REF: 101 Brookmans Avenue, Brookmans Park, AL97QG

Title: Non Material Minor amendments application house 1 AND 3
houses : 6/2019/2313/FULL

This application is for the alteration to approved drawings 485018-17/ 485018-19.

Dwg. No. 485018-17 Rev. f

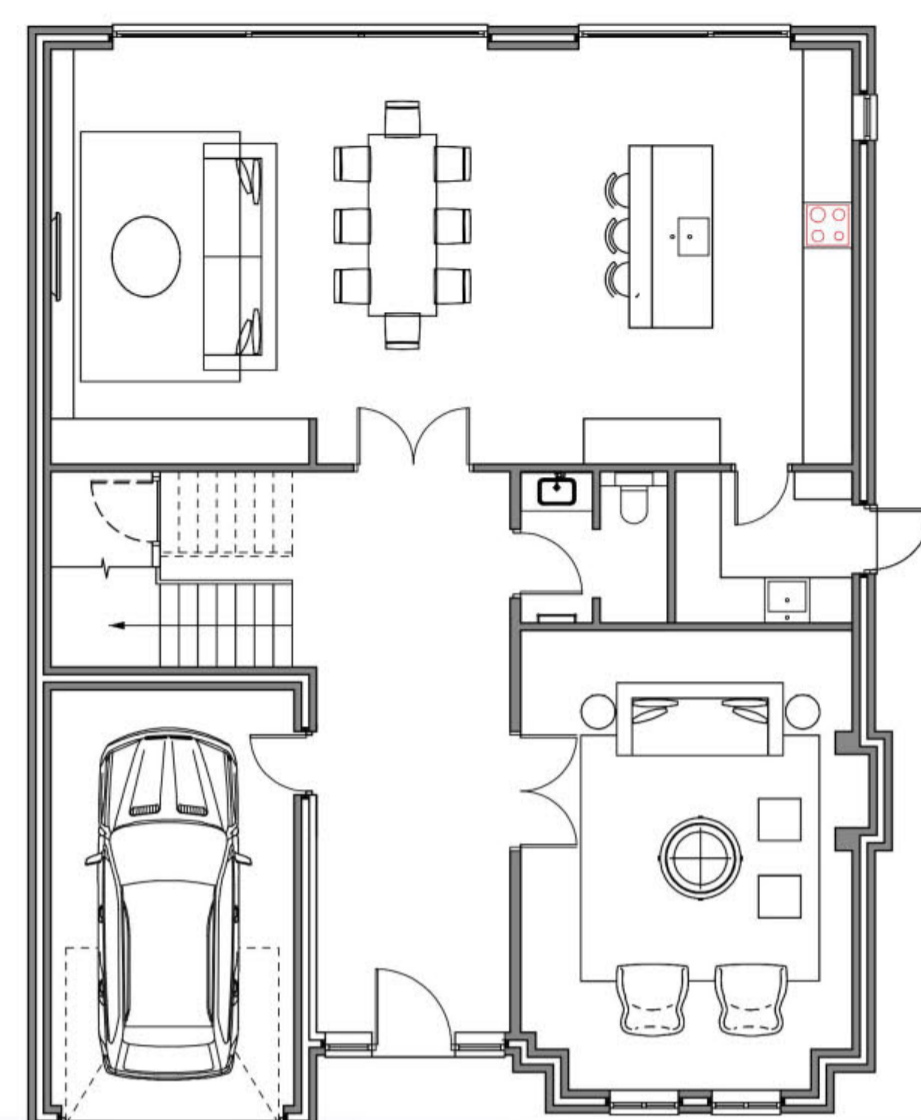
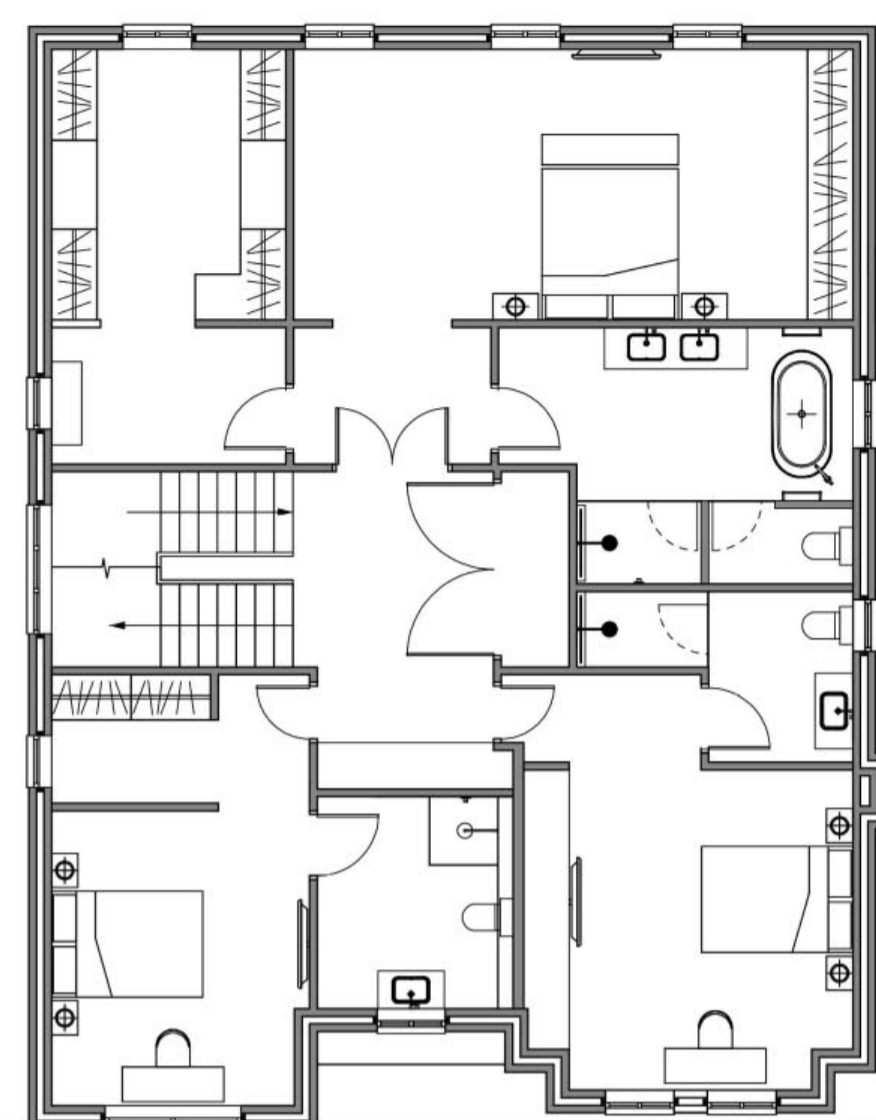
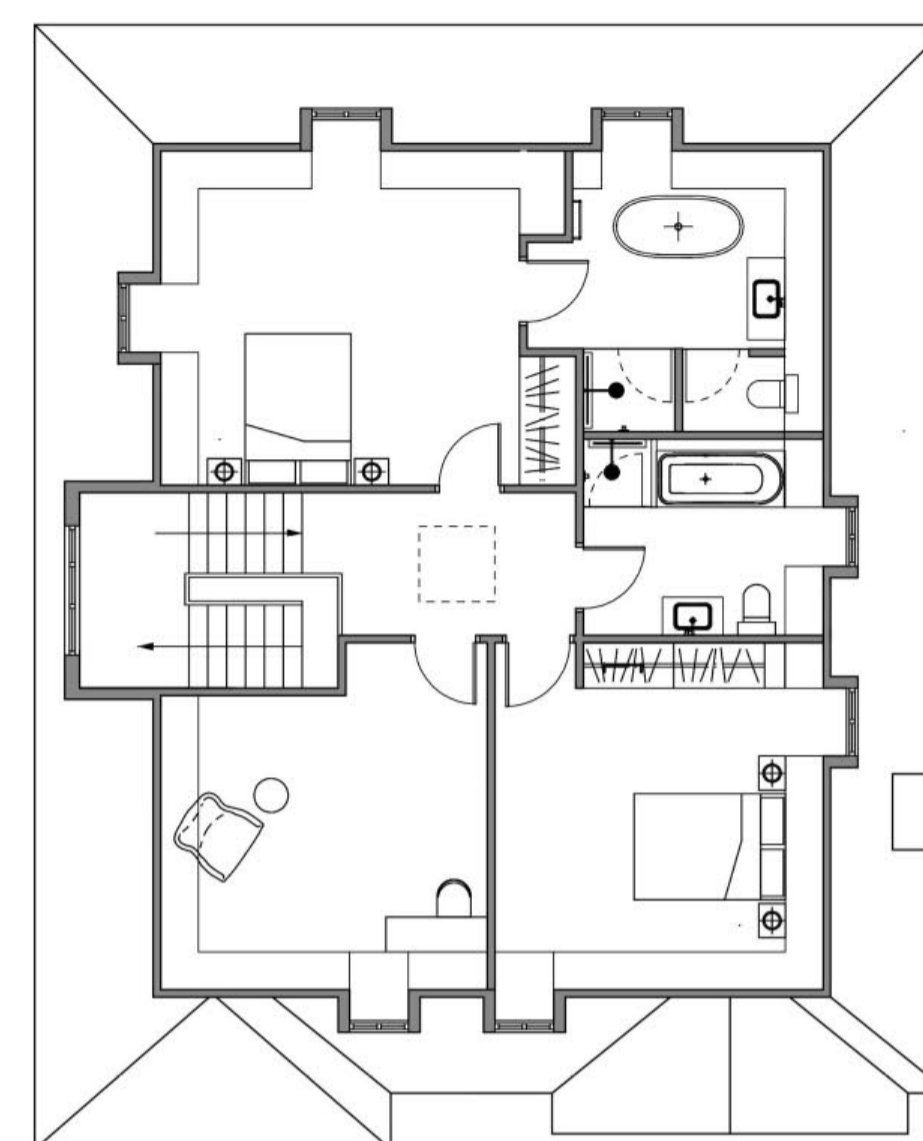
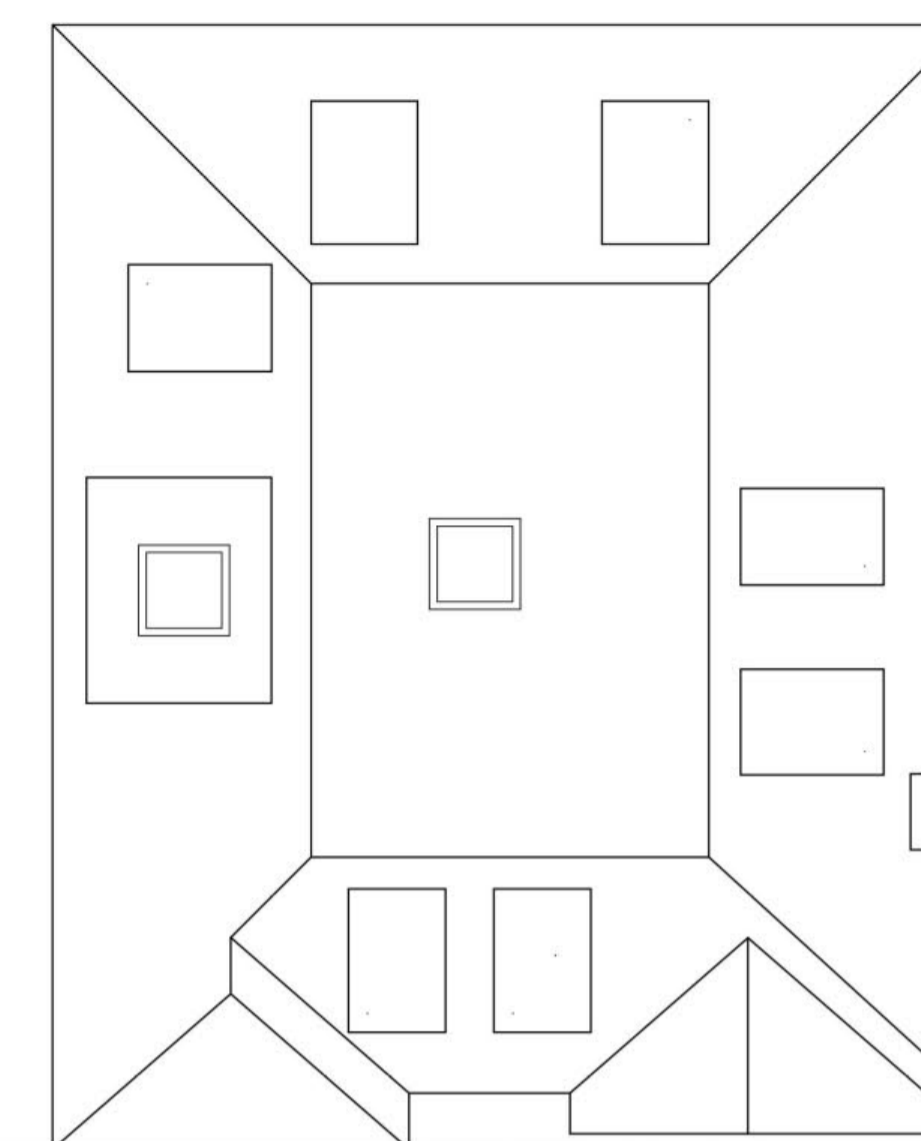
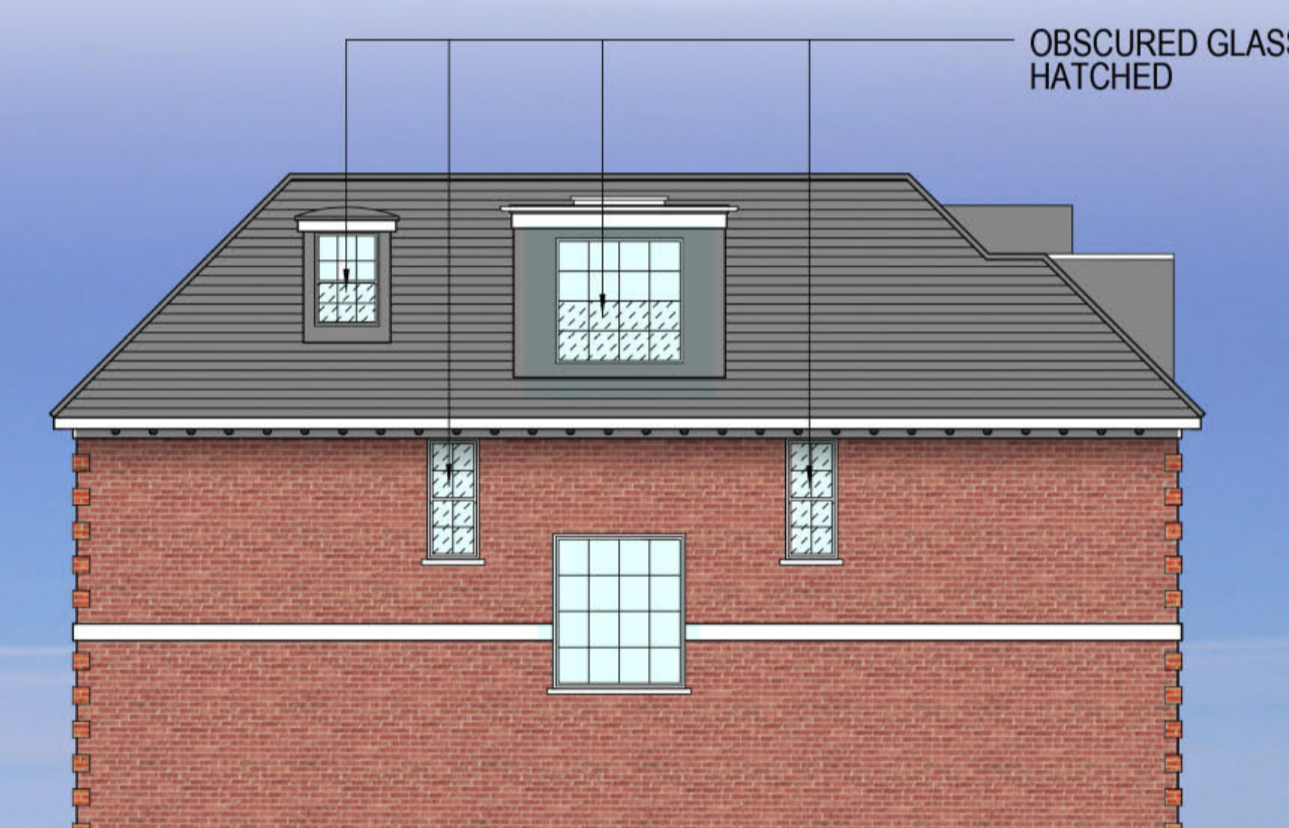
The main brickwork has had to change to the approved brick that is being used on the rear houses as there has been major supply issues of the original brick proposed.
